Application for a non-material amendment following a grant of planning permission.

SEVEN WIND TURBINES TO A MAXIMUM TIP HEIGHT OF 127M,
ASSOCIATED ELECTRICITY TRANSFORMERS, ACCESS TRACKS, UNDERGROUND
CABLING, ROTOR ASSEMBLY PADS, CRANE HARDSTANDINGS, ANEMOMETRY
MASTS, COMMUNICATIONS MAST, CONTROL BUILDING & SUBSTATION COMPOUND
FOR A PERIOD OF 25 YEARS

INCREASE TO AREA OF HARDSTANDING AROUND THE CONTROL
BUILDING & COMPOUND AS SHOWN OF DRAWING 01582D2307-03
AMENDMENT TO TRACK CONFIGURATION TO PERM MET MAST
AS SHOWN ON DRAWING 01582D1001-14

DRAWING NUMBER  
**01582D1001-14**

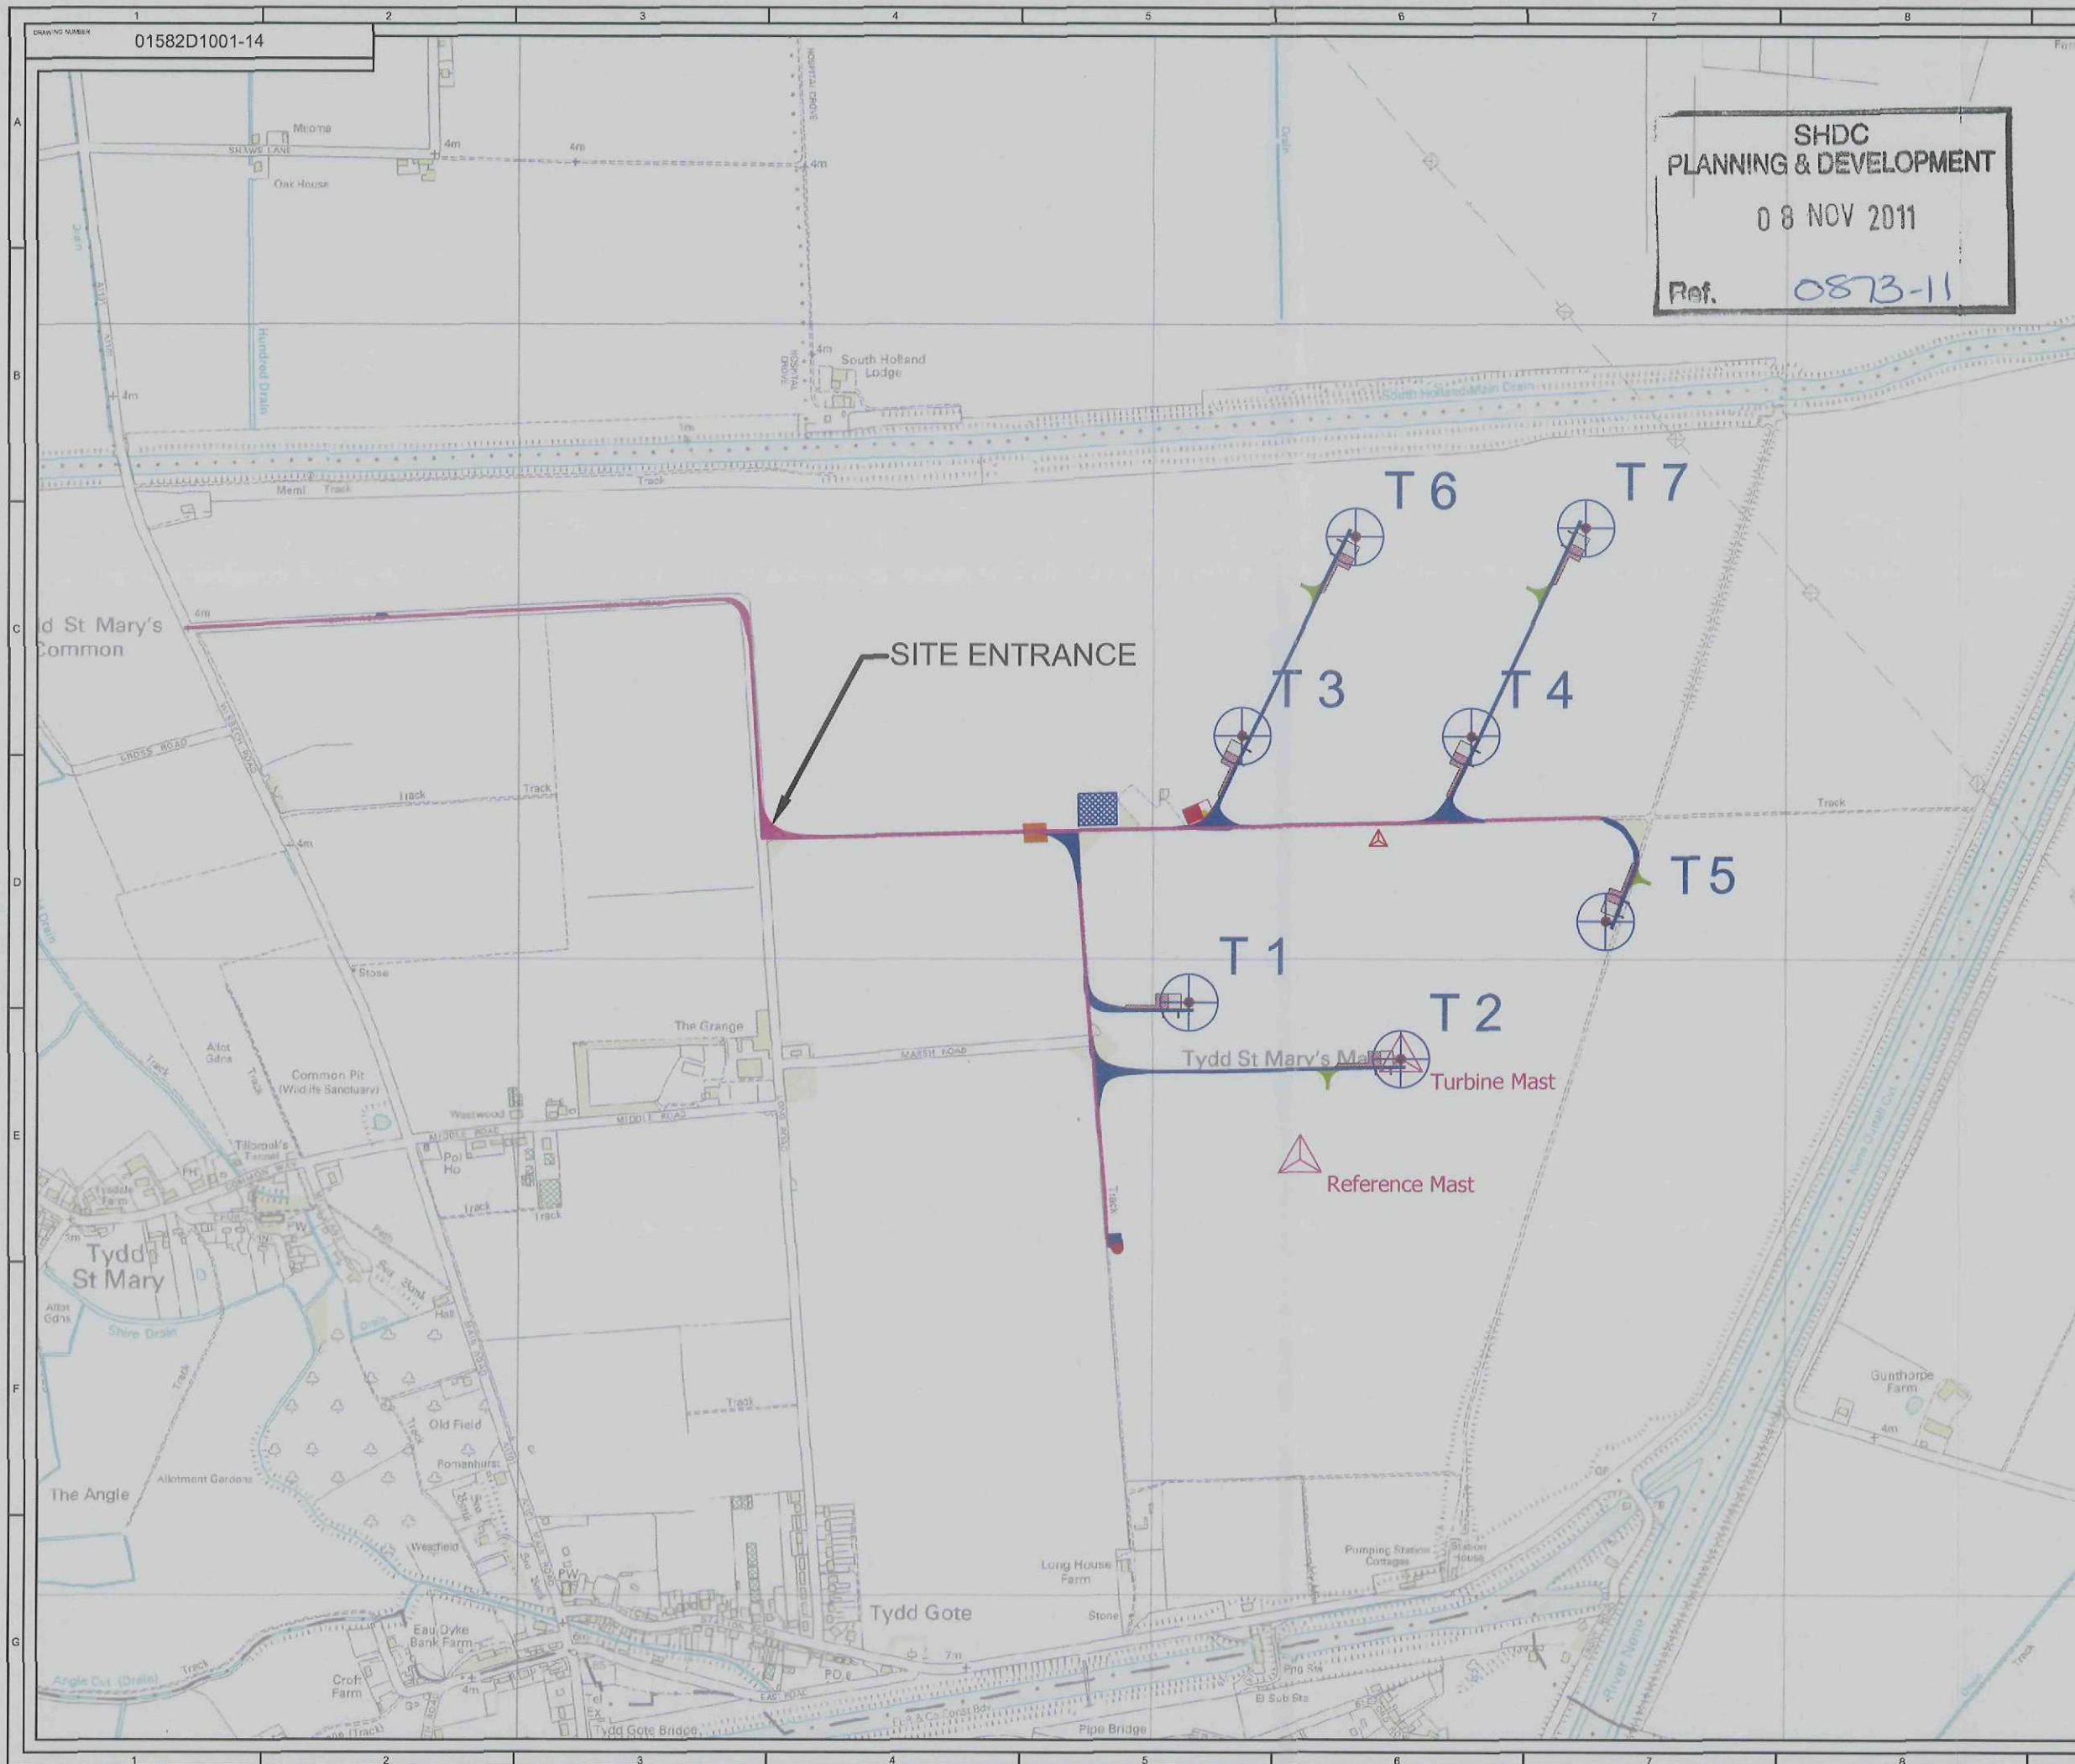
ALLOW EXTRA AREA FOR ACCESS TO BUILDING & COMPOUND
AREA FOR VEHICLES. TRACK REALIGNMENT FOR IMPROVEMENT
TO DESIGN.
